**CHERWELL DISTRICT COUNCIL**

**STATEMENT ON BEHALF OF THE LOCAL PLANNING AUTHORITY**

Appeal by Mr T Catling against the decision by Cherwell District Council to refuse full planning permission for the demolition of the existing chapel and erection of 1 dwelling.

Appellant : Mr Tim Catling  
Appeal Site : St George Catholic Church  
Road Close Road  
Adderbury  
LPA Reference : 17/02131/F  
Planning Inspectorate : APP/C3105/W/18/3204214  
Reference

East Elevation

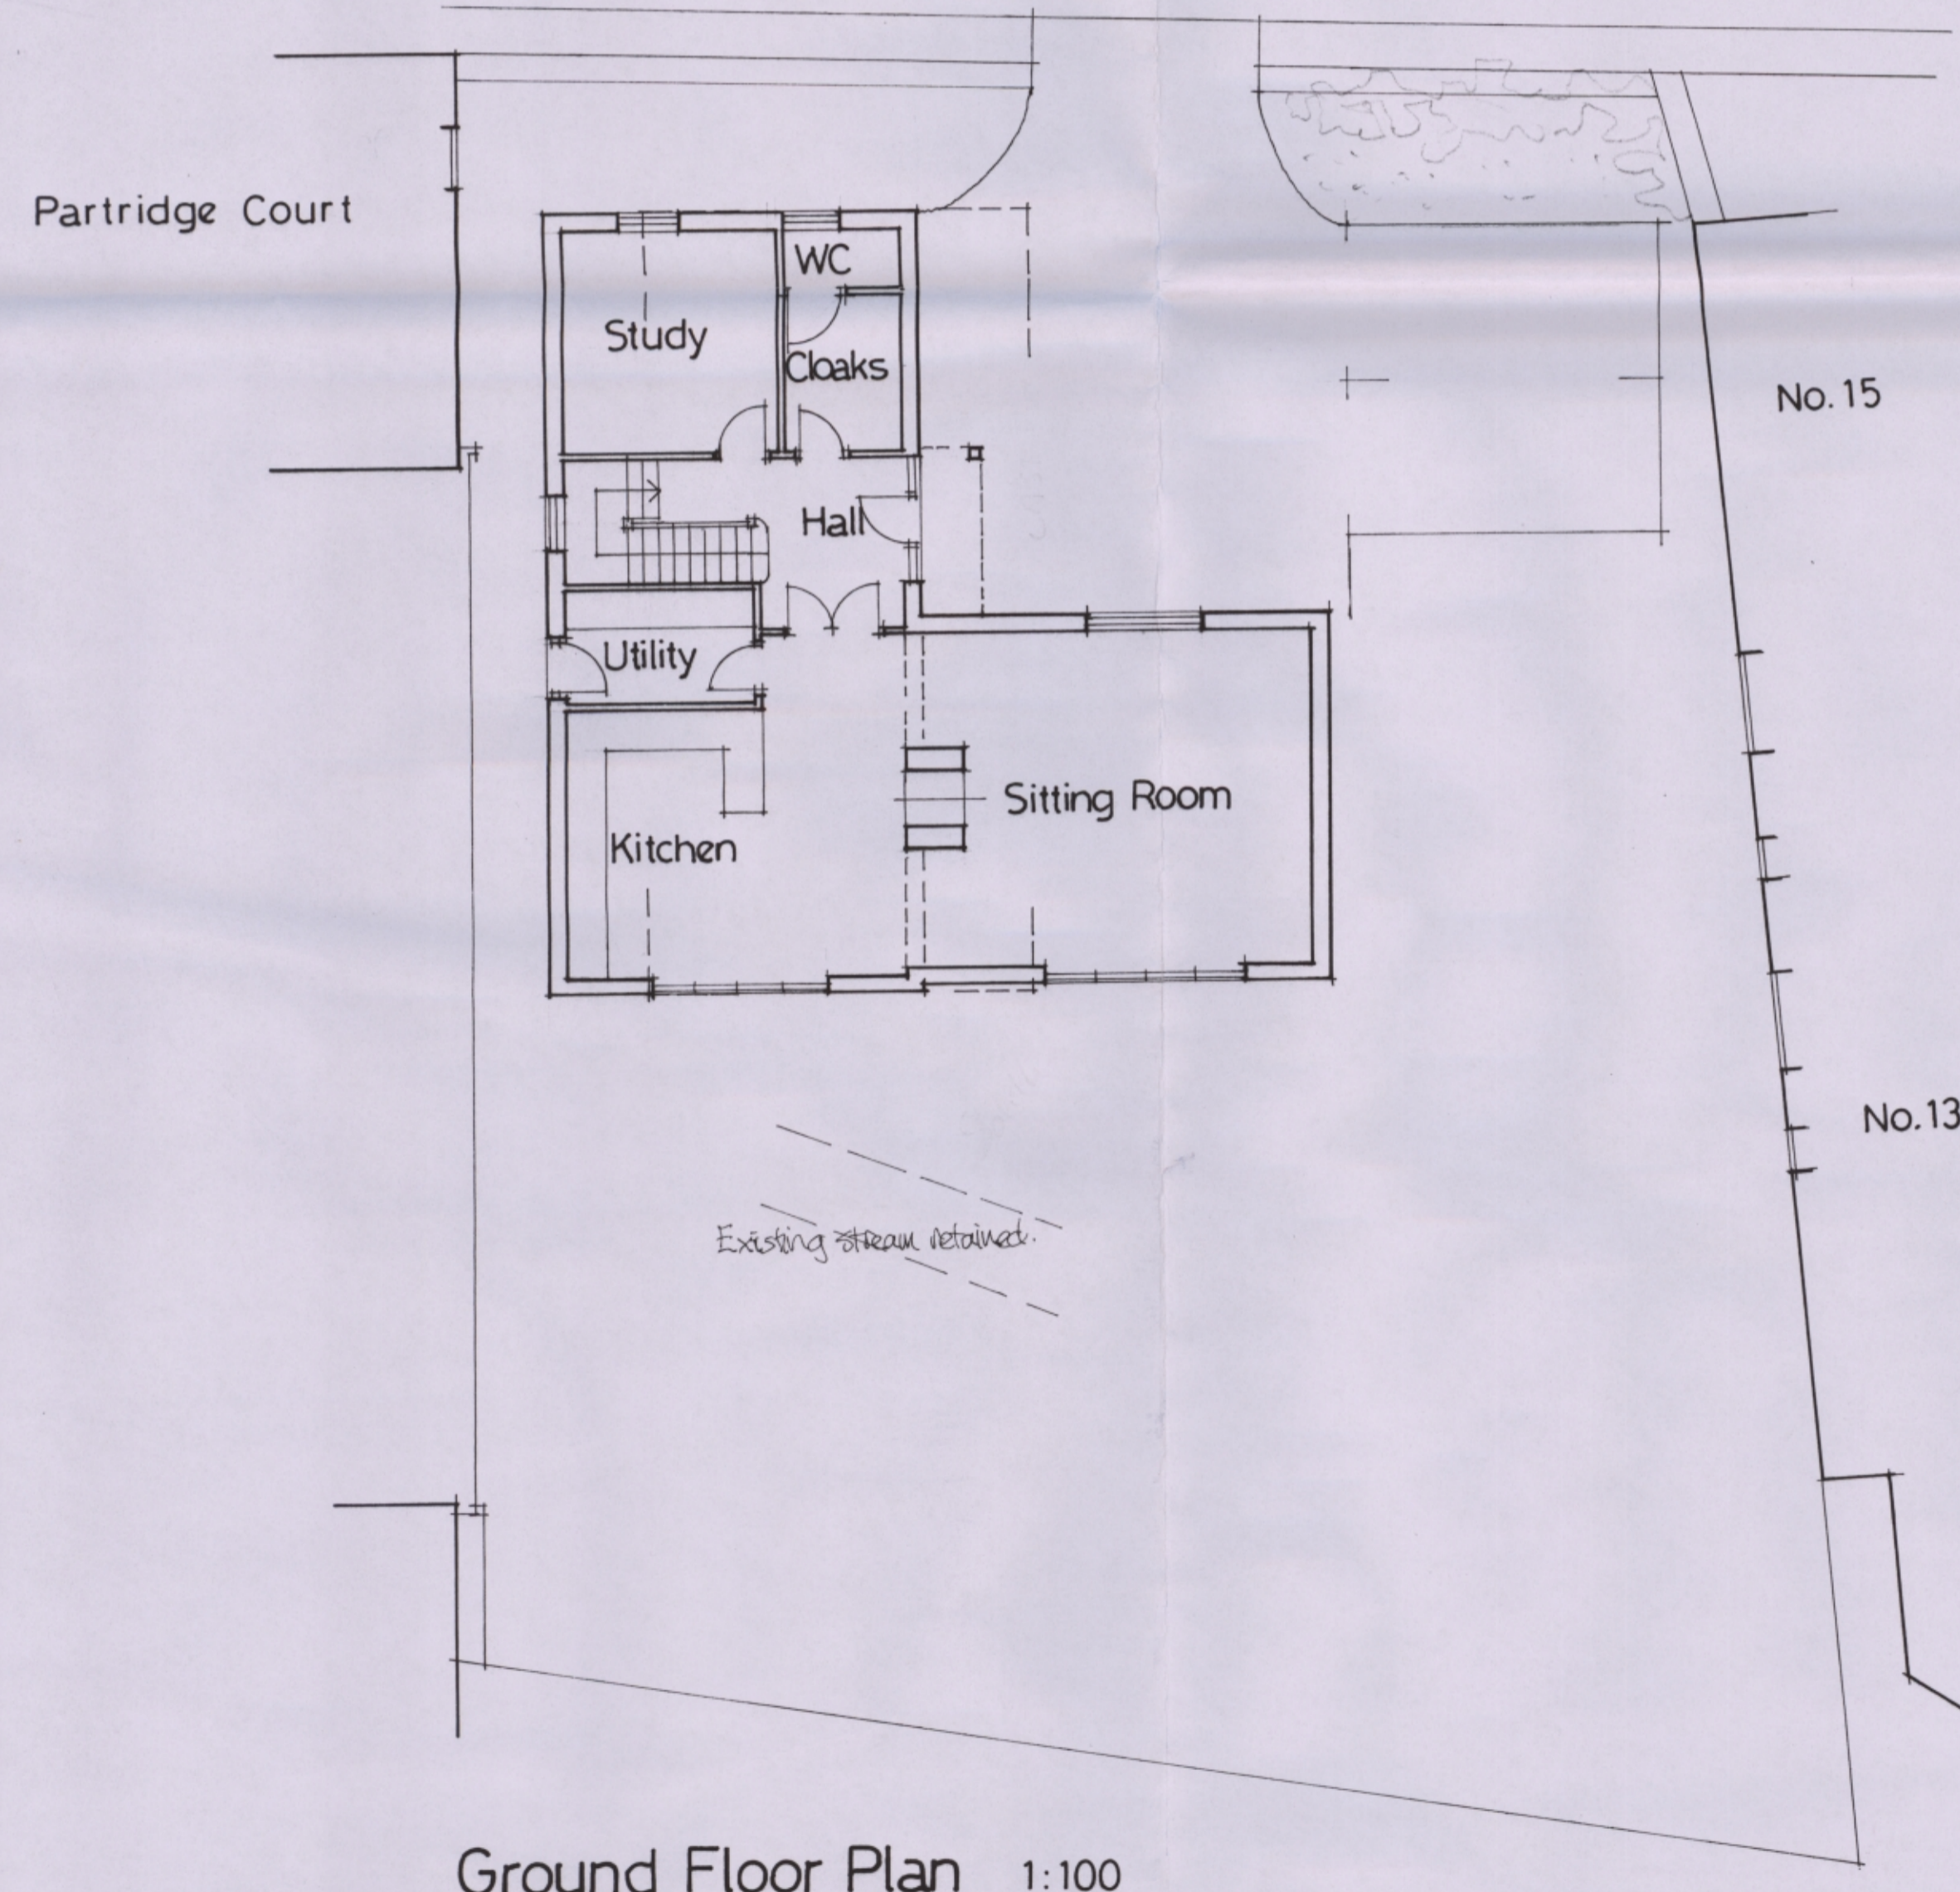
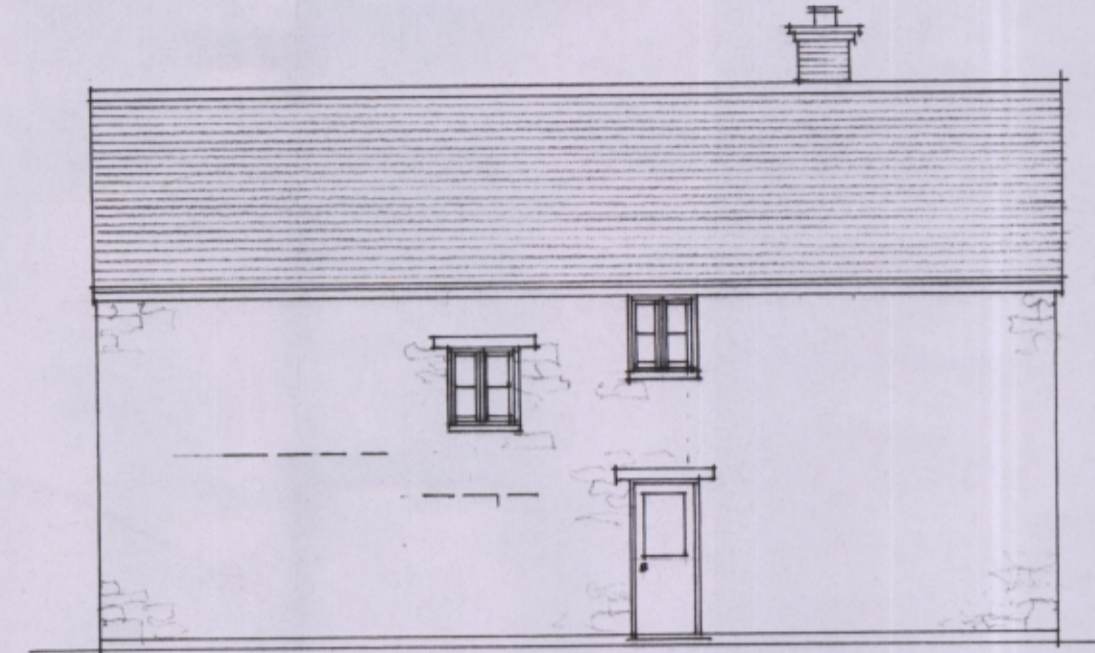
and reinforces local distinctiveness and positively responds to the attributes of the location. The proposed L shape arrangement of the dwelling, with large forward projecting gable element and car parking area dominating much of the frontage and hipped roof, would all result in a suburban form of dwelling inappropriate to its context. It would not respect the traditional siting and form of dwellings which characterise the area which have flat simple frontages with a strong relationship to the street creating a sense of enclosure which contribute positive to the historic growth and significance of the Conservation Area. The presence of strong building lines are noted throughout the Conservation Area Appraisal as being important characteristic of the area including section 8.1 relating to land use and street pattern.

- 5.8 The forward projecting gable and hipped nature of the roofs are also not traditional forms in the Conservation Area. This results in the property appearing like a modern 'estate like' property rather than following the local vernacular. Generally in the instances where properties do have gables ends facing onto the road, the whole or main element of the building is perpendicular to the road. Furthermore in the few instance where hipped roofs exist they are part of the ancillary elements to the buildings like on the adjacent building where the main element of the building faces Tanners Lane and the roof form is seen in that context. The appeal scheme however forms a detached dwelling in its own right with hipped roof and projecting gable which would out of character with the traditional form of buildings in the Conservation Area the locally distinctive building form consists of steeply pitched gable ended roofs running parallel to the highway. As noted at paragraph 6.4 and page 95 of the Cherwell Residential Design Guide SPD hipped roofs should generally be avoided as they create a suburban form uncommon to the Cherwell vernacular and page 94 indicated that front façades of buildings should be kept flat and avoid projecting elements. This is based on an analysis of the local vernacular.

- 5.10 The second reason for refusal relates to the Council's concerns regarding both the residential amenity of the proposed dwelling and also the amenity of the existing dwellings adjacent to the site. As outlined in the report the neighbouring properties to the east have habitable ground floor windows facing directly onto the application site immediately on the eastern boundary of the site. The Council considers that given the location of the existing windows on the neighbouring properties, alongside the proximity and scale of the proposed dwelling, that it would unacceptably impact on the outlook and appear overbearing from the ground floor windows on the neighbouring properties.

Ground Floor Plan 1:100

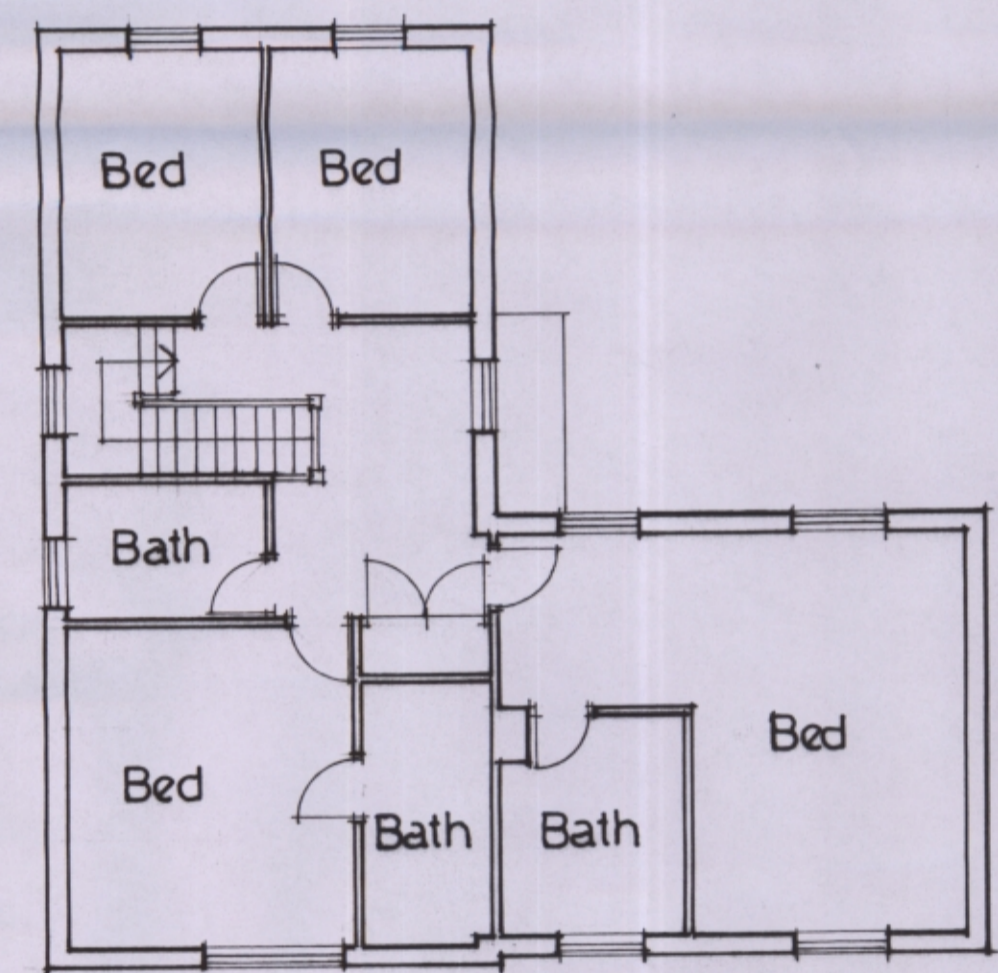
- 5.7 The proposal would rather follow the style and form of more modern infill development which does not respect the historic form of development and would fail to positively reinforce local distinctiveness resulting in a weak frontage dominated by a parking area.

- 5.11 The change of use of the land to a private residential garden would also result in the land immediately outside these existing windows being used for garden land associated with the development. This would result in future residents being able to view directly into these private habitable spaces of the neighbouring properties when using their garden to the significant detrimental of the amenity of the existing residents. Whilst it is accepted that such overlooking can already occur from within the grounds of the church, the change of use to residential garden would significantly increase the periods of usage of the outdoor space and hence the increase the occurrences when such overlooking and loss of privacy would happen. Likewise the garden which would serve future residents would be significantly overlooked by these existing windows with the private amenity space of the proposed dwelling being significantly overlooked and failing to provide a good standard of amenity for future occupiers of the dwelling. Overall the proposal is therefore considered to be contrary to Policy ESD15 of the CLP 2031 Part 1 and advice in the NPPF in this respect.
